Appeal Decision

Appeal Ref: APP/R5510/X/21/3280182

3 Copse Wood Way, Northwood, HA6 2TP

- The appeal is made under section 195 of the Town and Country Planning Act 1990 as amended against a refusal to grant a certificate of lawful use or development (LDC).
 - The appeal is made by Mr Harrison Reeves against the decision of London Borough of Hillingdon.
 - The application ref: 22134/APP/2021/1790, dated 4 May 2021, was refused by notice dated 28 June 2021.
 - The application was made under section 192(1)(b) of the Town and Country Planning Act 1990 as amended.
 - The development for which a certificate of lawful use or development is sought is a detached outbuilding.
-

Drawing
Proposed Composite Planning Drawing

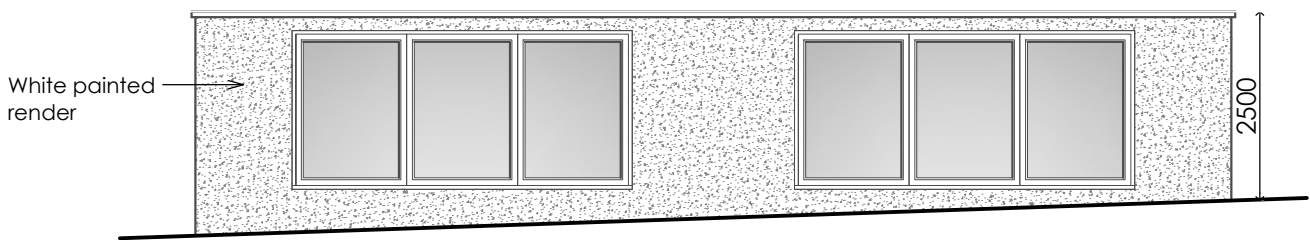
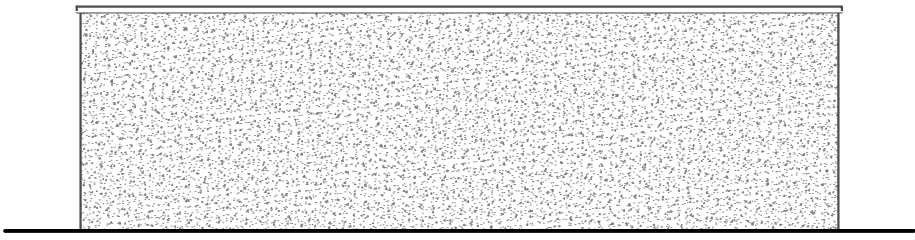
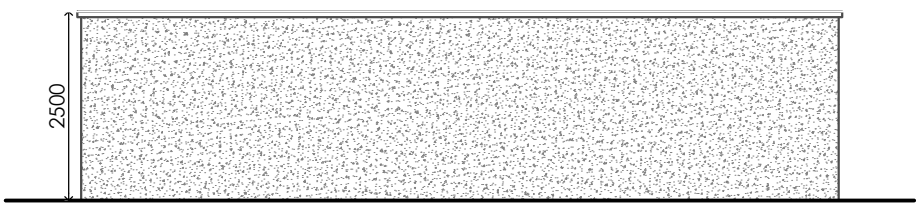
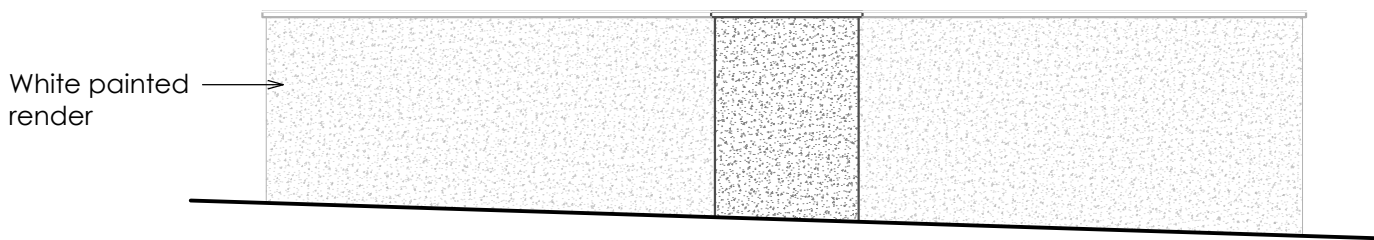
6. There is no dispute, as shown clearly on the submitted layout plan, that the proposed building would come within 2m of the boundary of the curtilage to the dwellinghouse. The height of the building therefore cannot exceed 2.5m. Article 2(2) of the GPDO states that *"Unless the context otherwise requires, any reference in this Order to the height of a building or of plant or machinery is to be construed as a reference to its height when measured from ground level; and for the purposes of this paragraph "ground level" means the level of the surface of the ground immediately adjacent to the building or plant or machinery in question or, where the level of the surface of the ground on which it is situated or is to be situated is not uniform, the level of the highest part of the surface of the ground adjacent to it"*.

7. Based on the above, taking the highest part of the surface of the ground adjacent to the building, the height of the flat roof would be 2.5m. However, the Government's 'Permitted development rights for householders - Technical Guidance 2019' sets out that if any part of the building is within 2m of the boundary of the curtilage of the house, then the height limit for the total development is restricted to 2.5 metres if it is to be permitted development. In this case, due to a slope of the land the height of the building would be greater for some parts than 2.5m.

9. The total building would exceed the height limitation under Class E.1(e)(ii) of the GPDO. Therefore, it is development that does not have planning permission by virtue of the GPDO. As such, carrying out the development in the absence of planning permission would be unlawful.
